GLEN AT WIDEFIELD FILING NO. 9
FINAL DRAINAGE PLAN
DEVELOPED CONDITION
EL PASO COUNTY, COLORADO

Sheet 2 - Final Drainage Plan Developed Condition

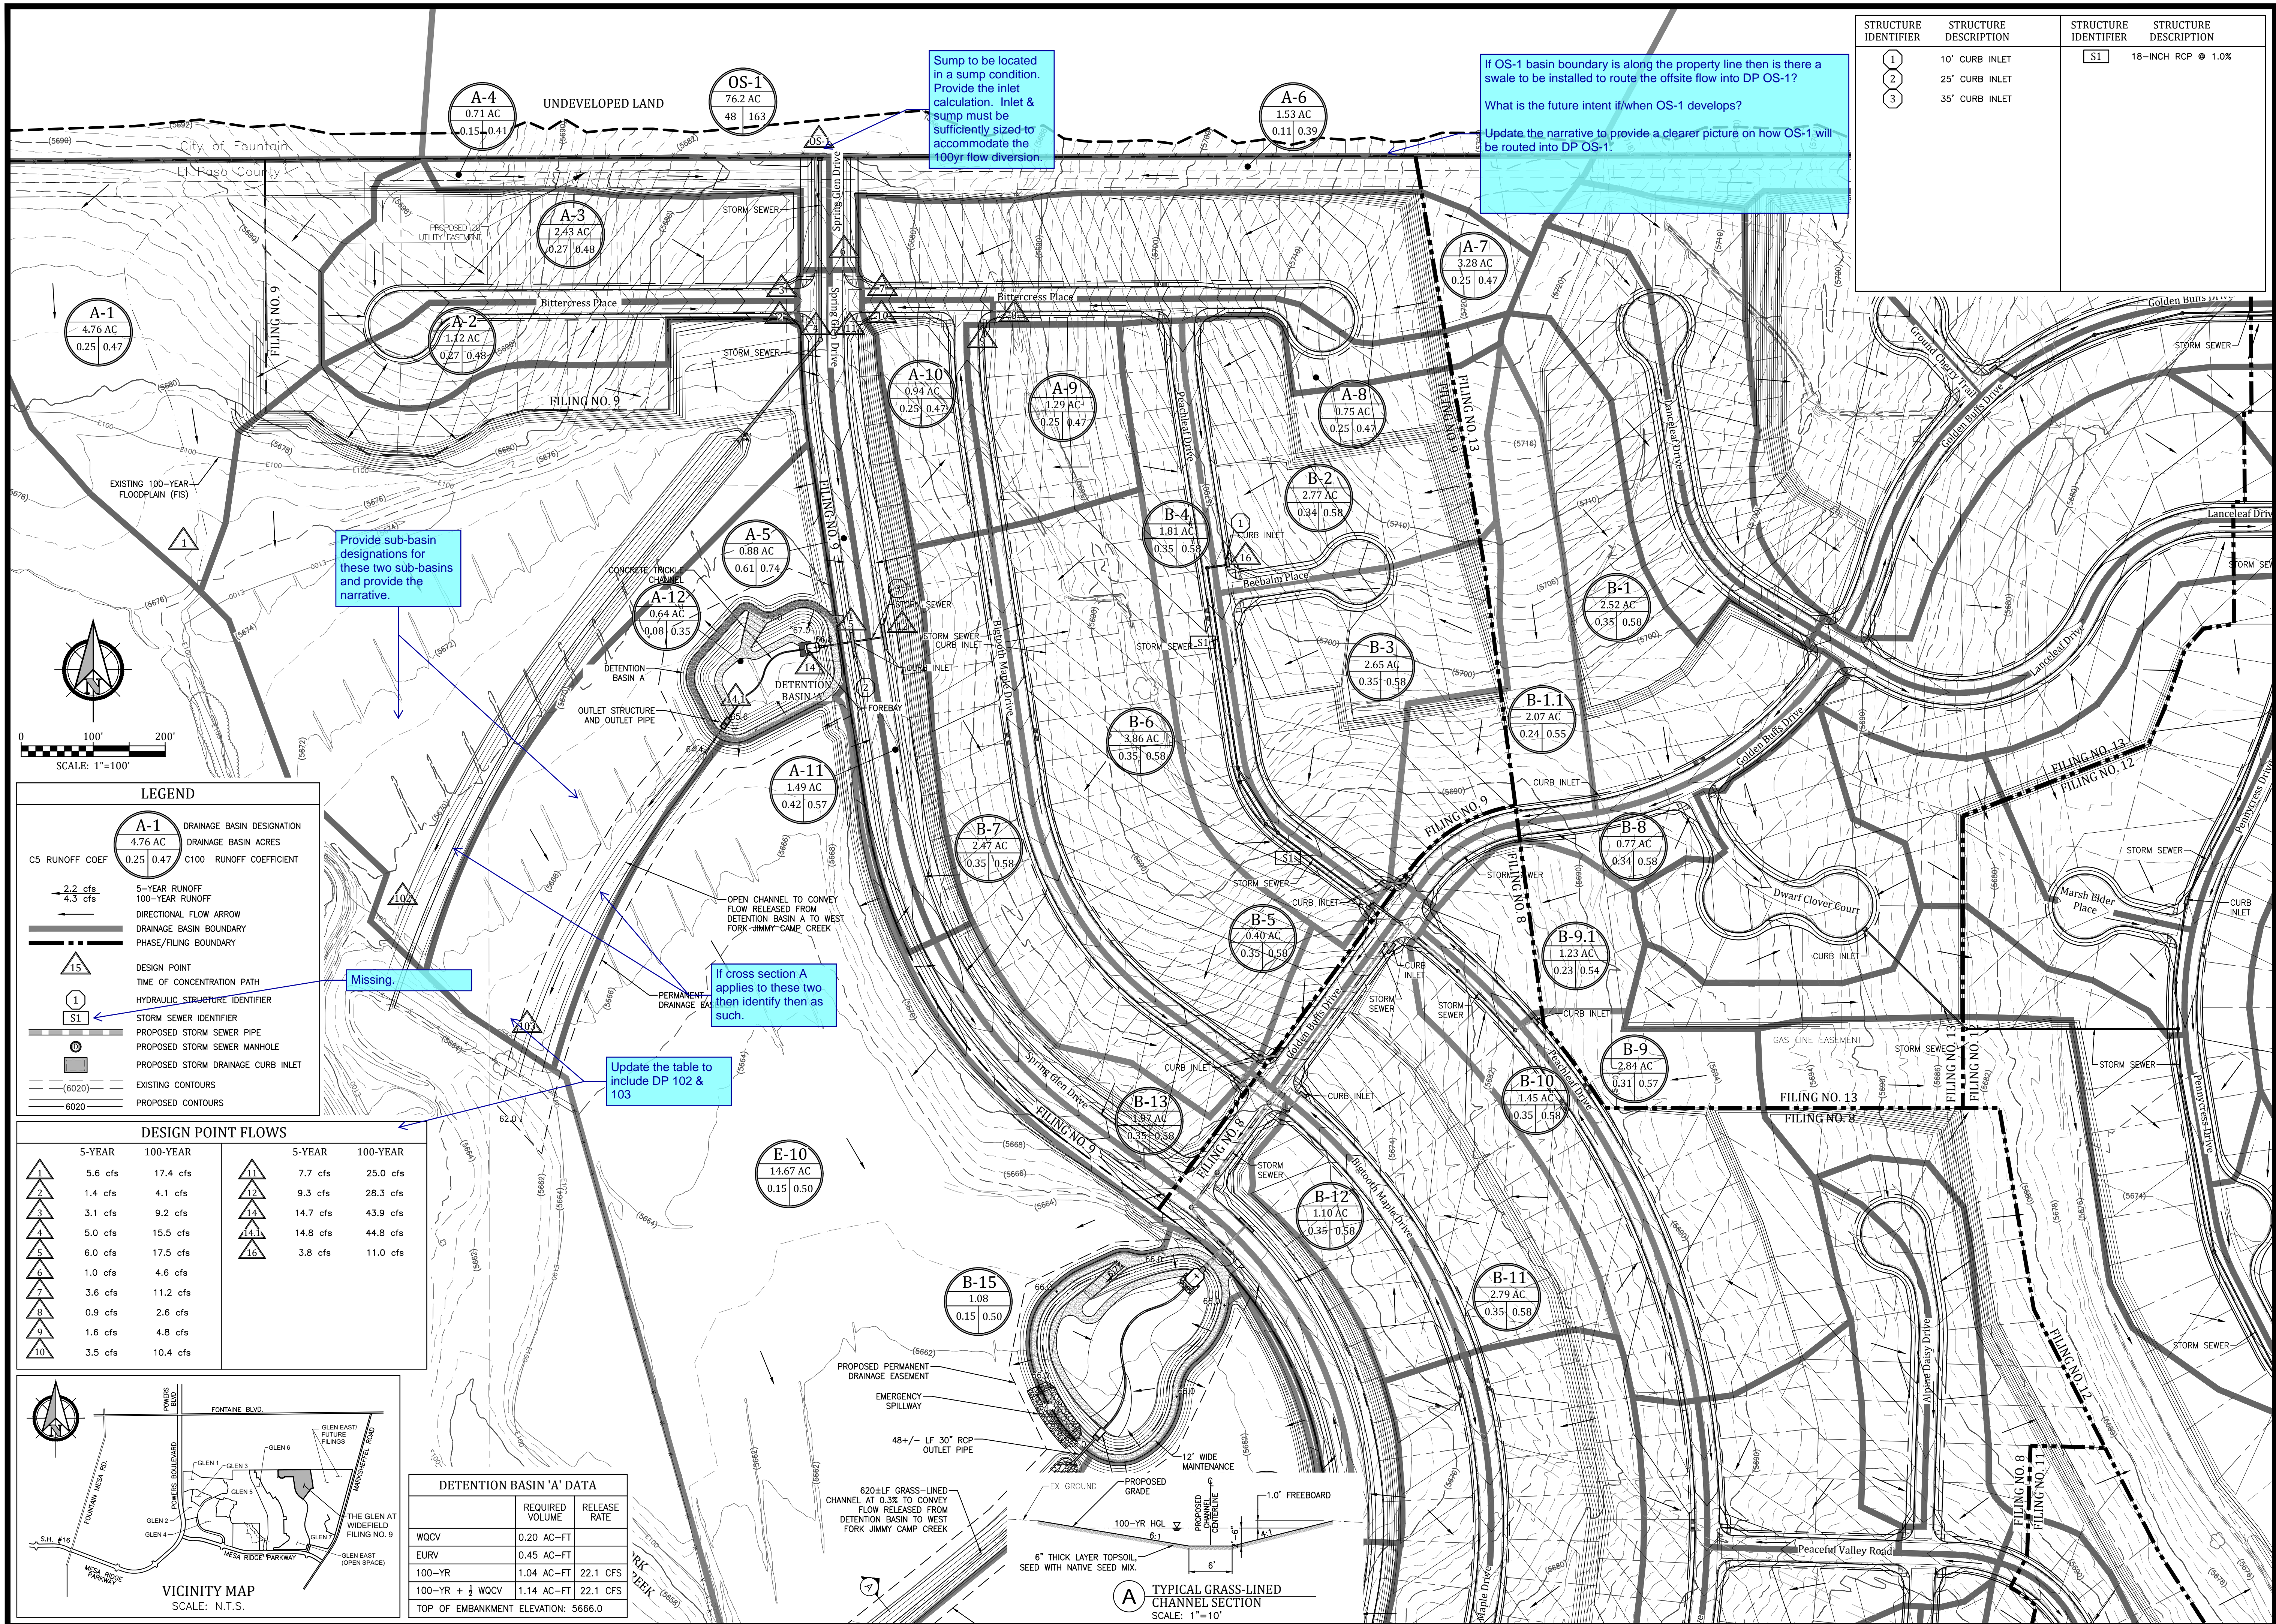
The MDDP drainage map (Fig 4) identified constructing riprap channel and a 4'Hx8'W CBC to convey flows from DP3060. The drainage design does not seem to account for conveying the offsite flow through the subdivision.

show the proposed contours

OPEN CHANNEL TO CONVEY FLOW RELEASED FROM DETENTION BASIN A TO WEST FORK JIMMY CAMP CREEK

Remove "Future". EDB A is being constructed with filing 9, therefore the easement must be in place with this filing.

Provide the open channel analysis in the drainage report

Update values for required volume. See redline comments to page 8 of the drainage report
